Environment, Development & Transport Committee

Report title:	Hornsea Project Three Windfarm Consultation
Date of meeting:	15 September 2017
Responsible Chief Officer:	Tom McCabe - Executive Director, Community and Environmental Services
Strategic impact The above offshore windfarm and onshore grid connection infrastructure will be determined as a Nationally Significant Infrastructure Project under the Planning Act 2008. Norfolk County Council is a statutory consultee on such projects and therefore has the opportunity to comment and influence the final decision. Responding to such consultations will ensure the County Council's views are formally taken into account prior to a final decision being made by the Secretary of State.

Figure 1.1: Screening Assessment – Onshore HVAC Booster Station.

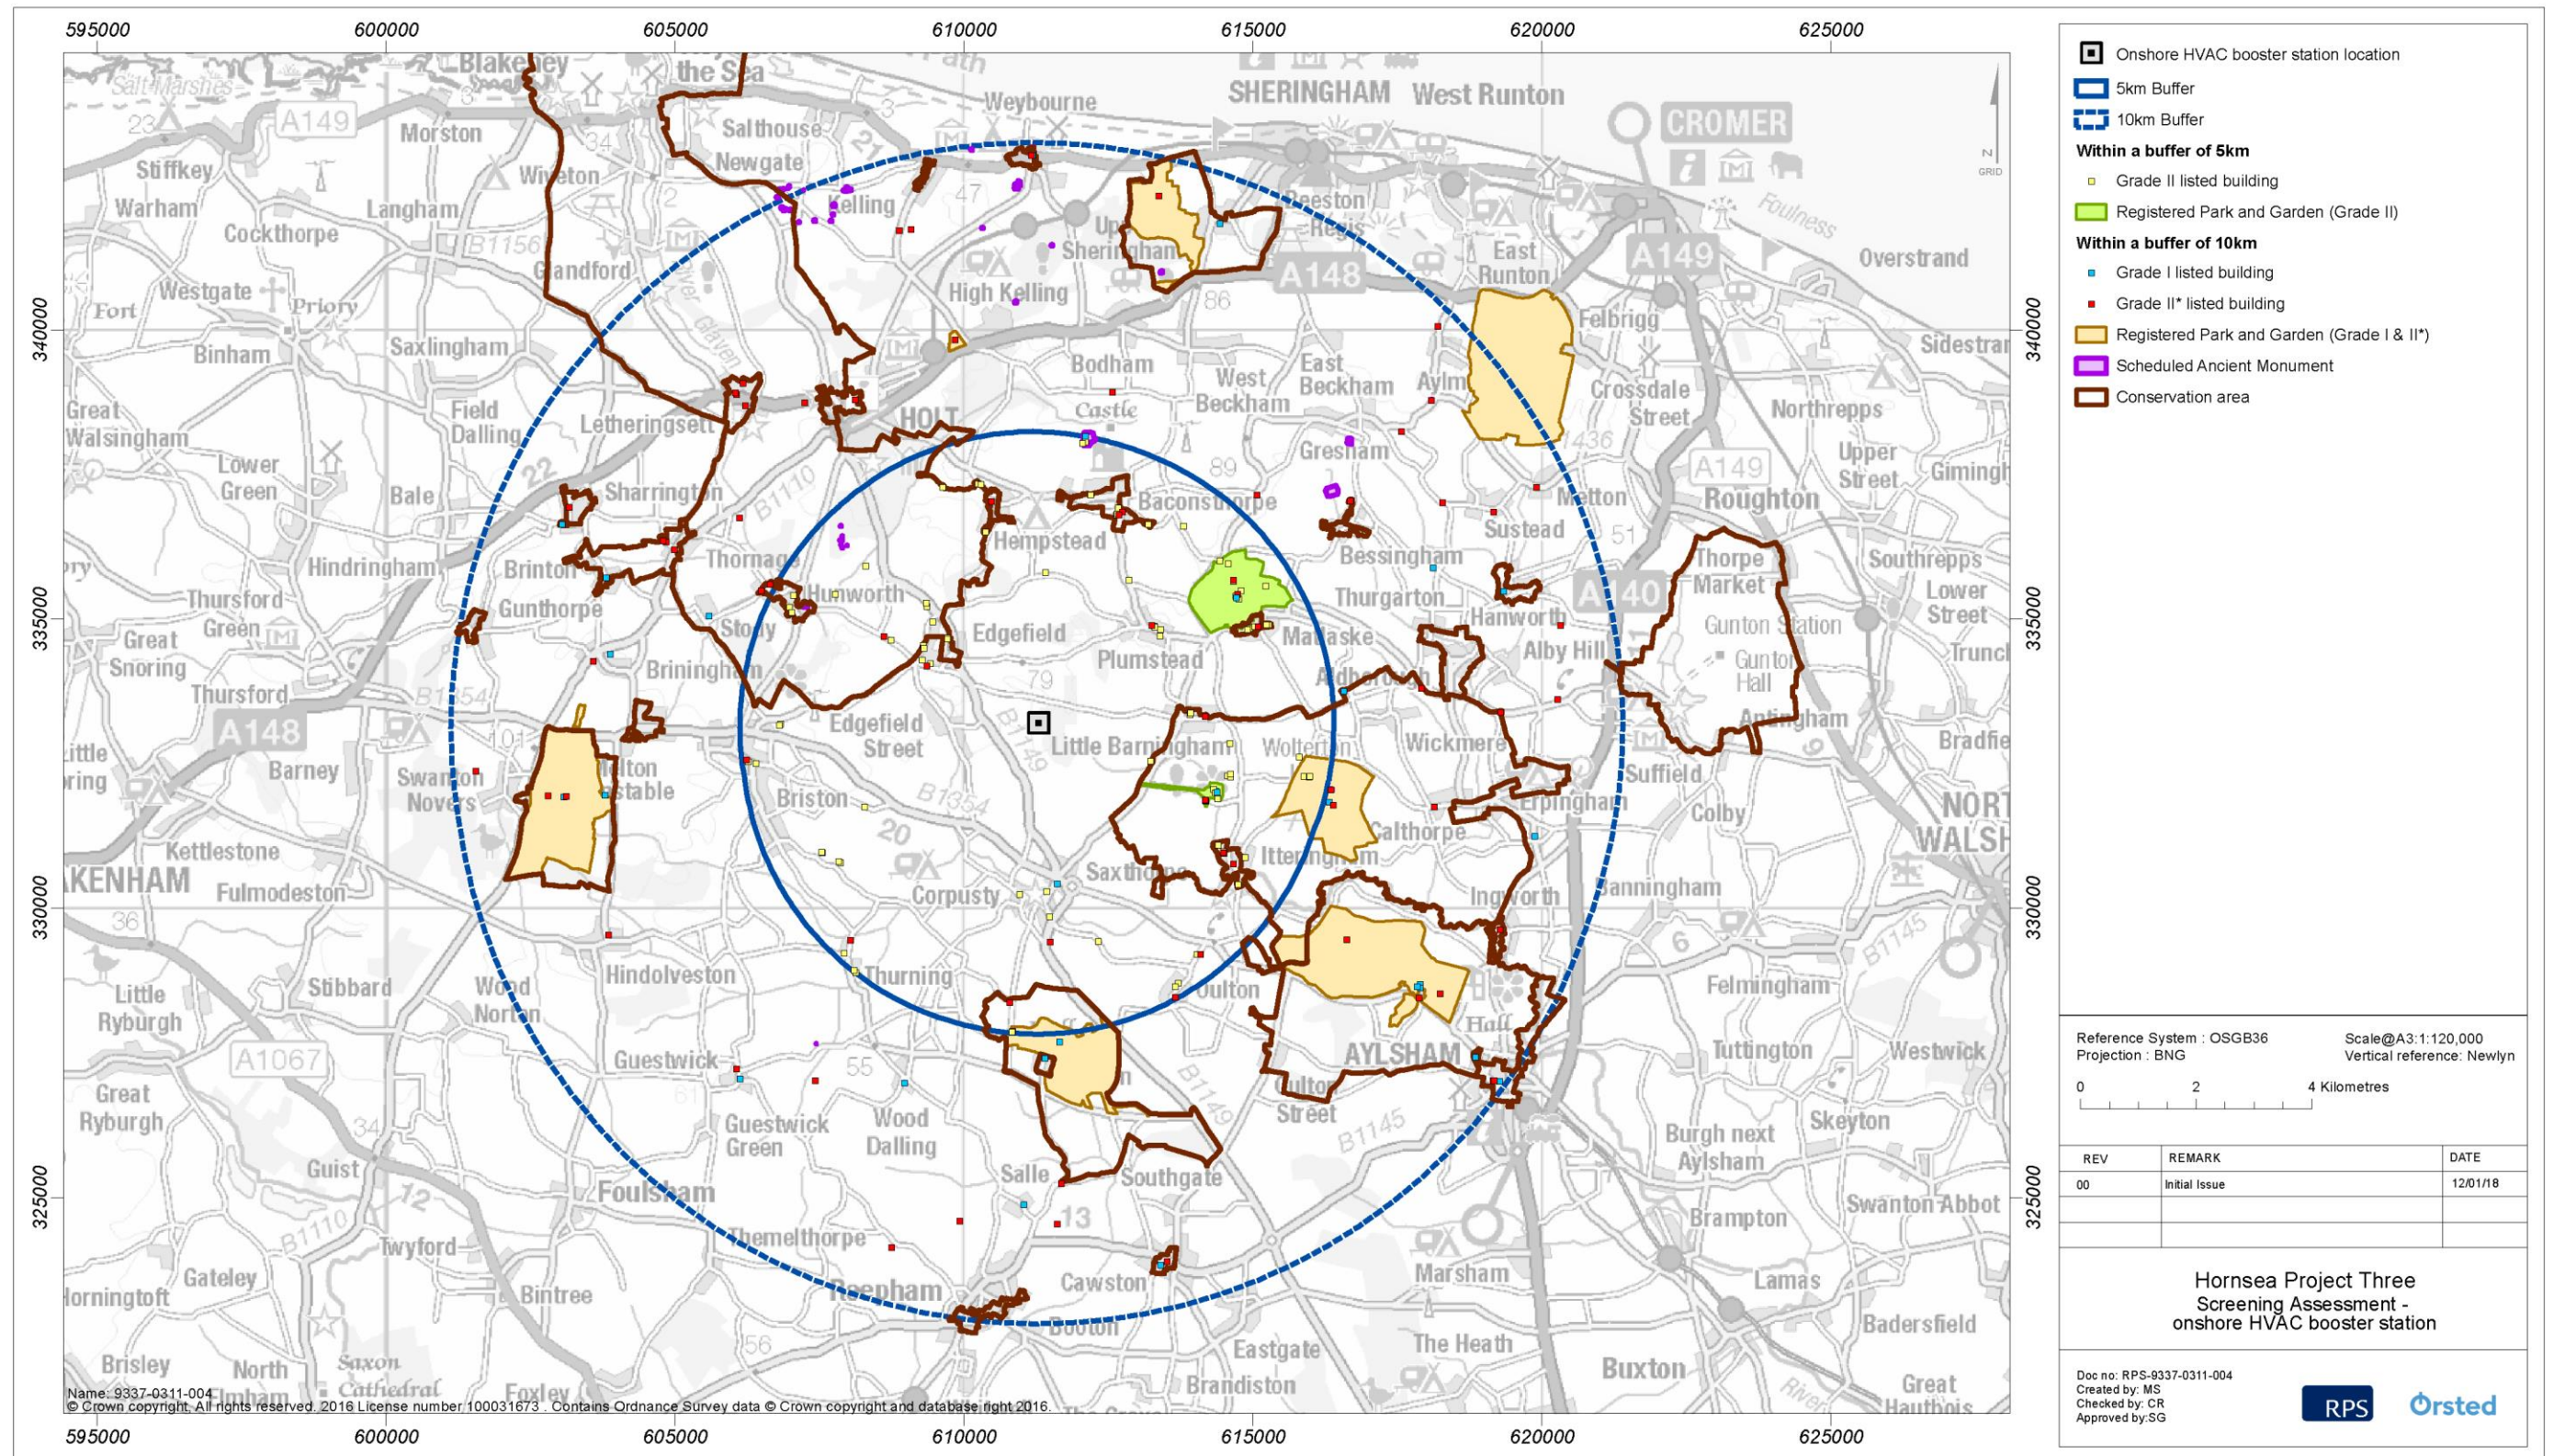
2.8. As indicated above the proposal could involve either HVAC or HVDC technology or a combination of both. The advantage of using HVDC for transmission purposes would result in removing the need for a HVAC Relay station. The Booster Station has a footprint of 25,000 sq.m. and a height of 12.5 metres. While the applicant has not ruled out the use of HVDC technology, it is felt that

every effort ought to be made to enable a HVDC solution, which would remove the need for the HVAC Station between Edgefield and Saxthorpe.
